# CITY OF ALBUQUERQUE

July 16, 2025

**RE: Ventana Square Self-Storage  
9610 Universe Blvd. NW  
Grading and Drainage Plan  
Engineer's Stamp Date: 7/8/25  
Hydrology File: B10D003C3C  
Case # HYDR-2025-00250**

Based upon the information provided in your submittal received 07/11/2025, the Grading & Drainage Plans **are not** approved for Building Permit Approval. The following comments need to be addressed for approval of the above referenced project:

G&D 1

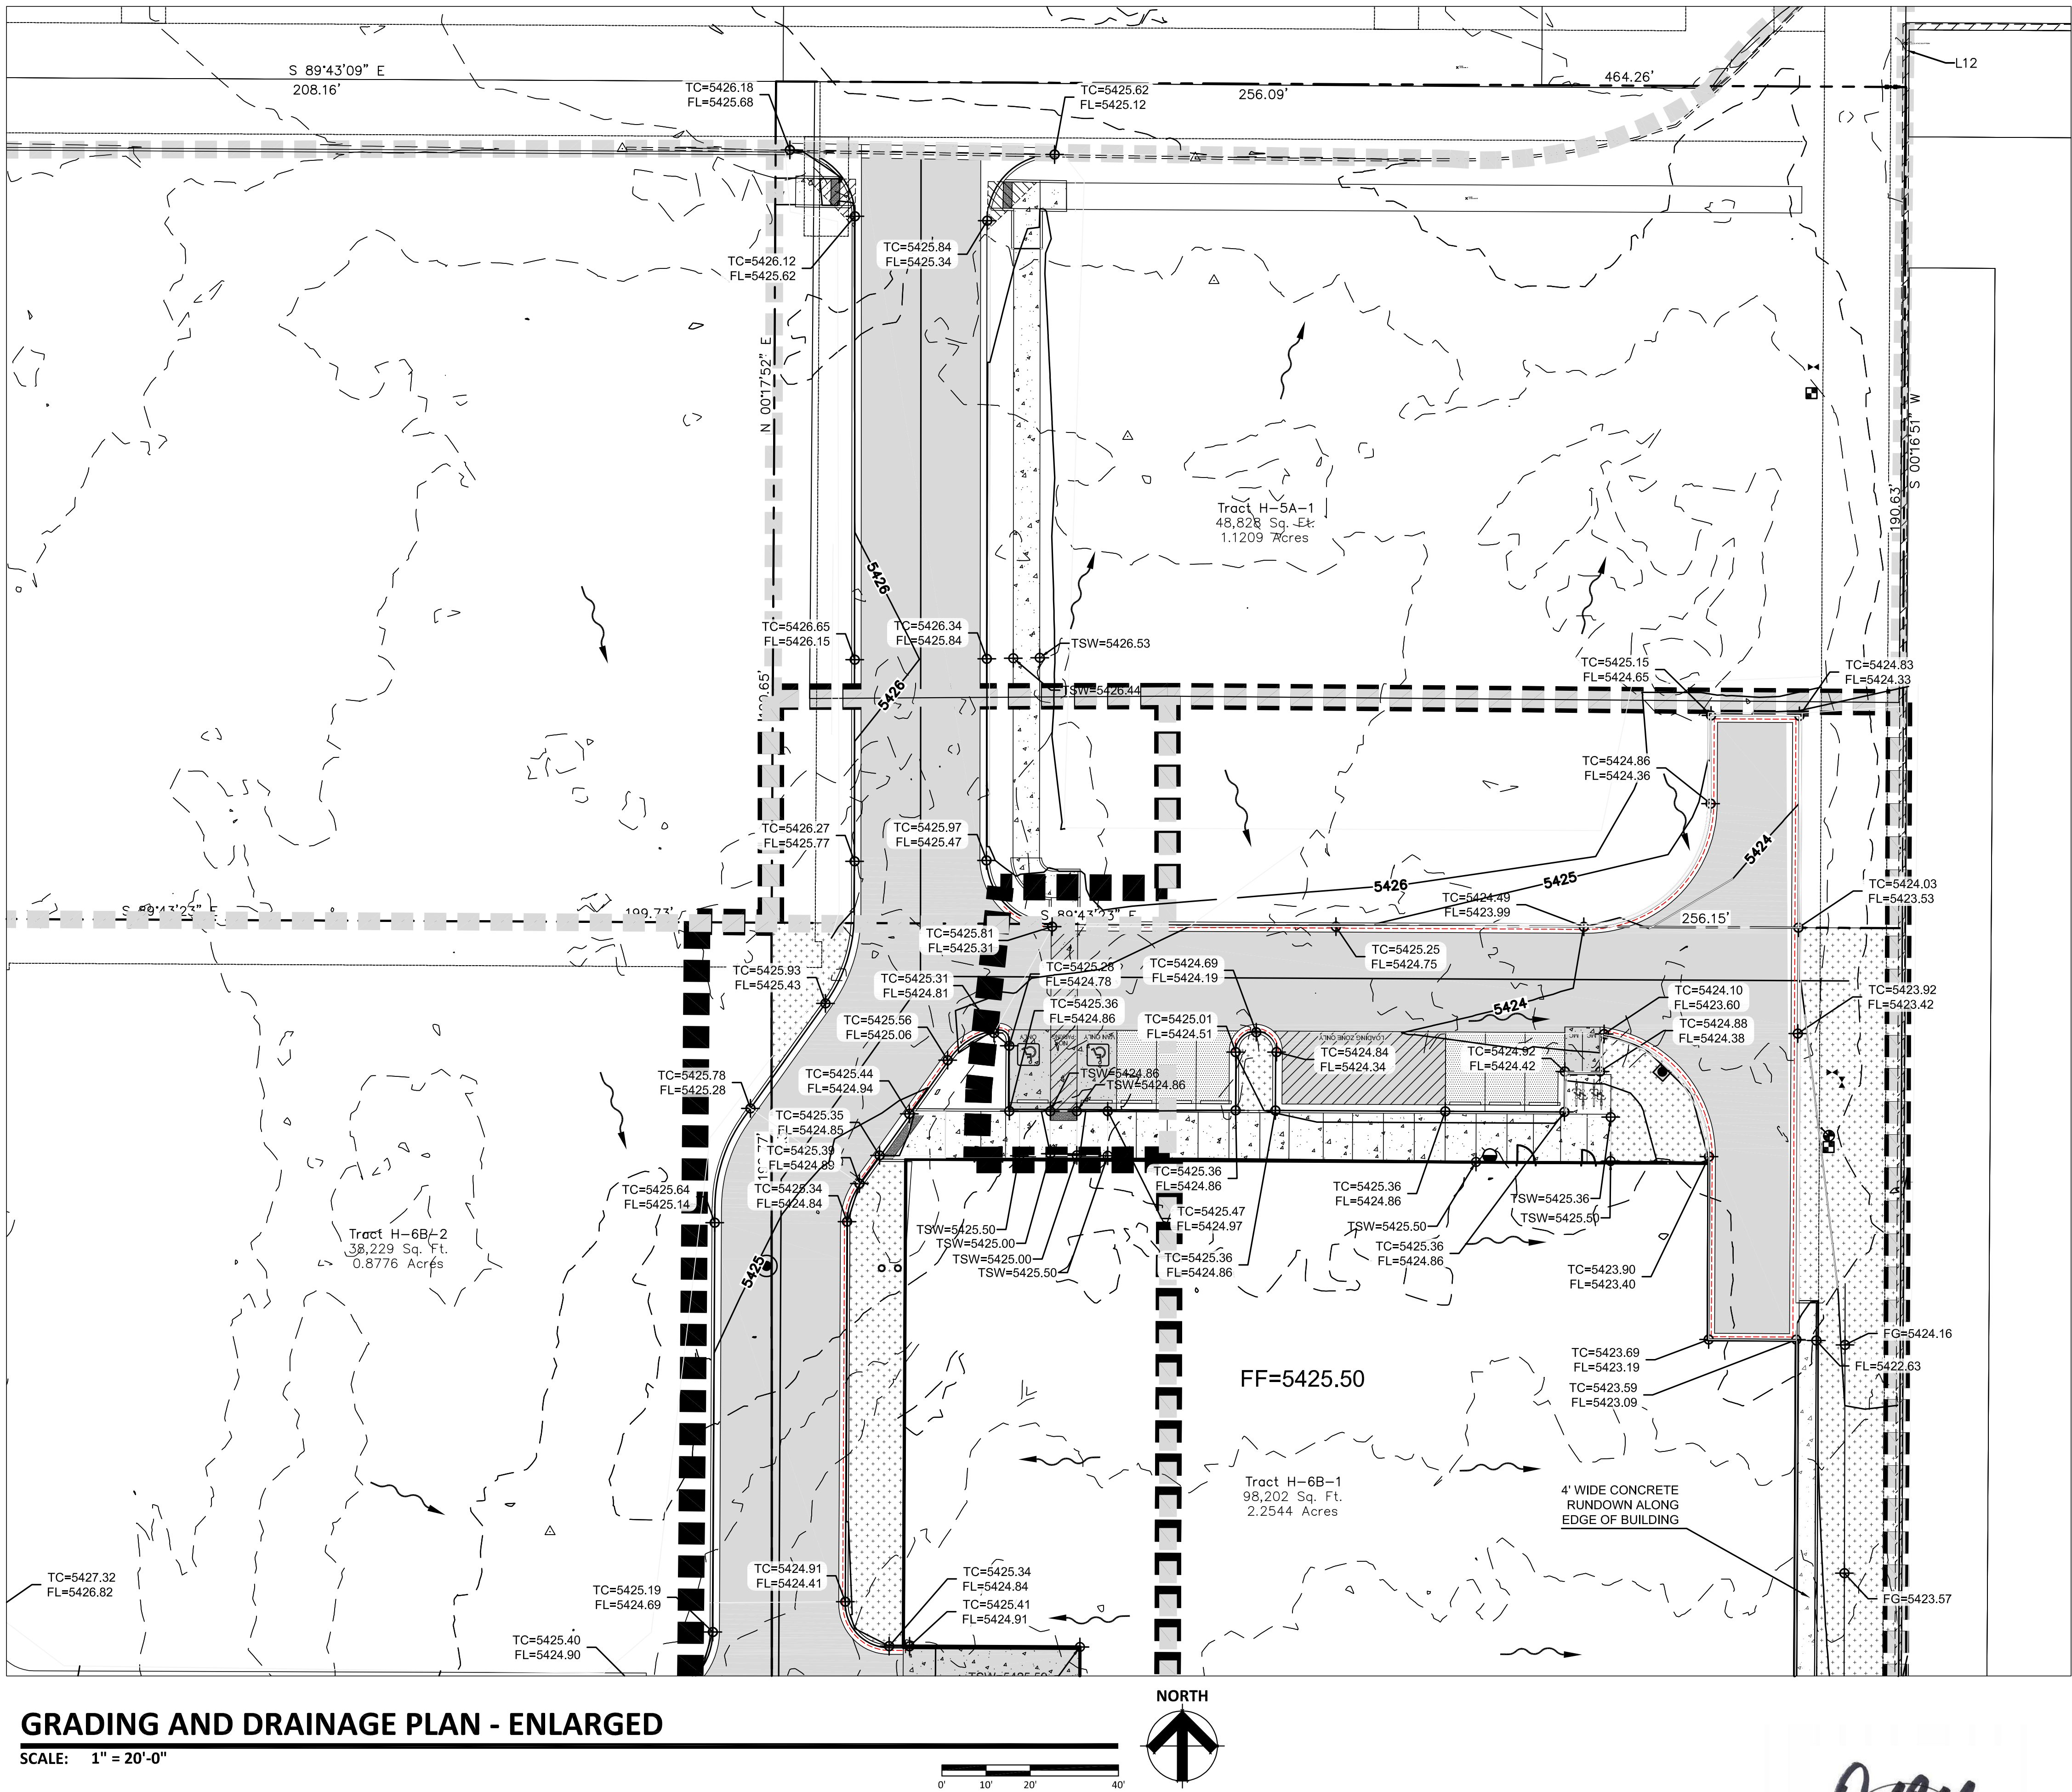
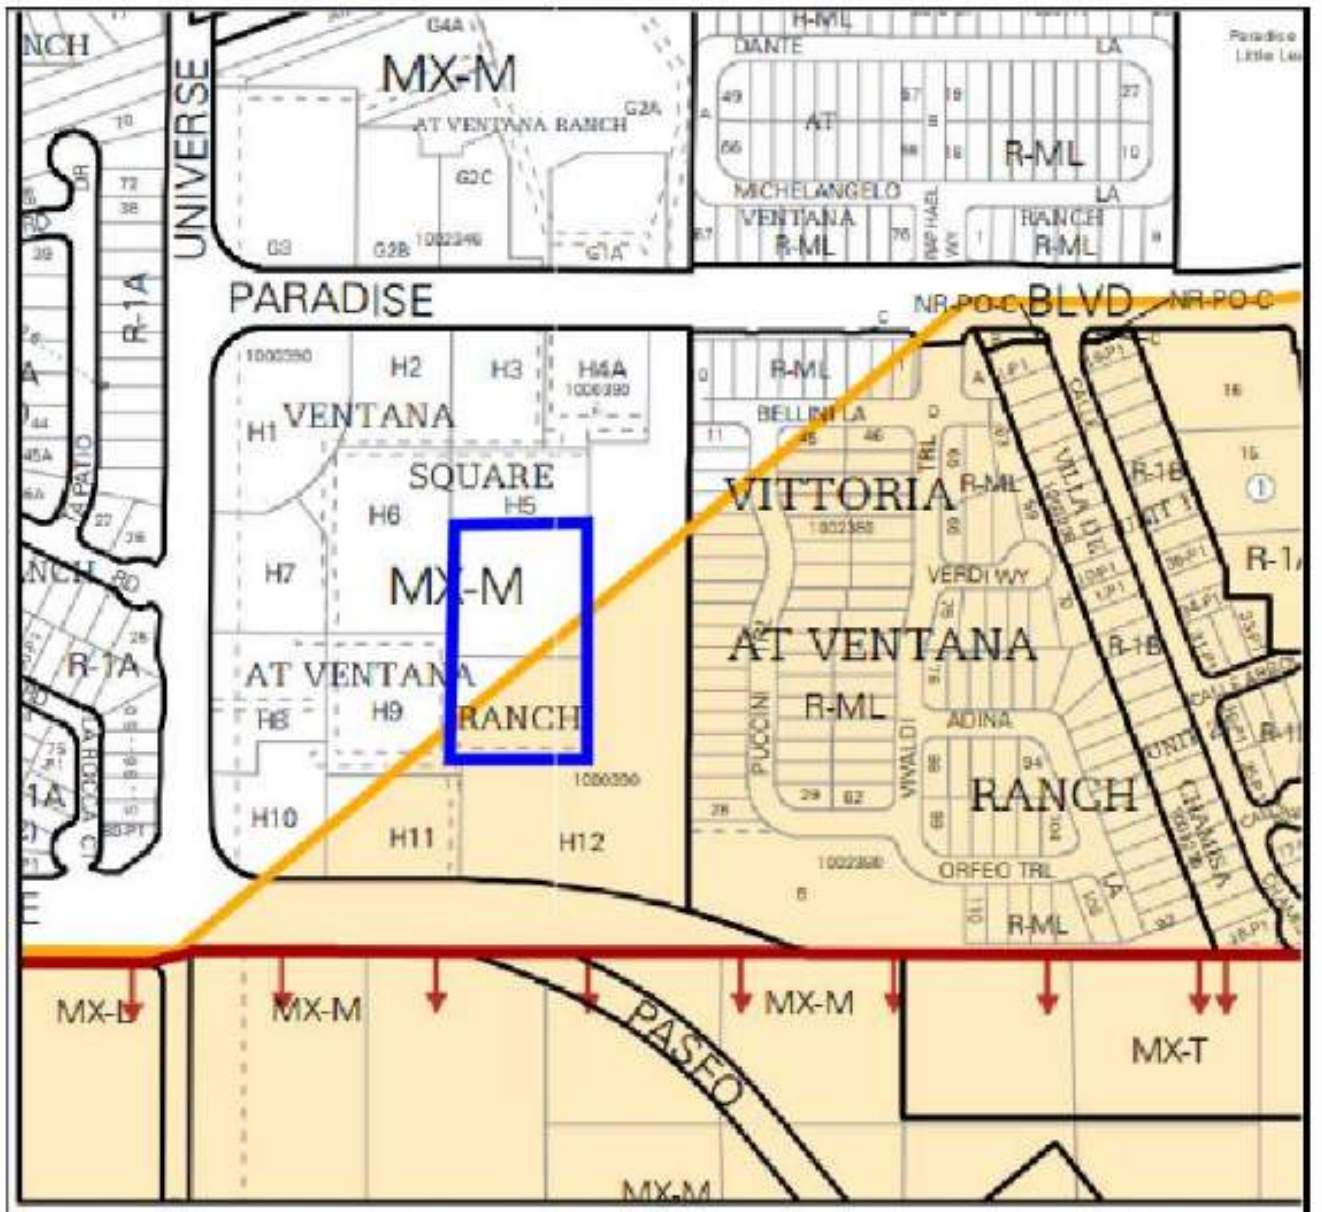
1. Reference Zone Atlas Page B-10 in the Purpose and Scope section.

2. Fix the text overlap so that the information is readable.
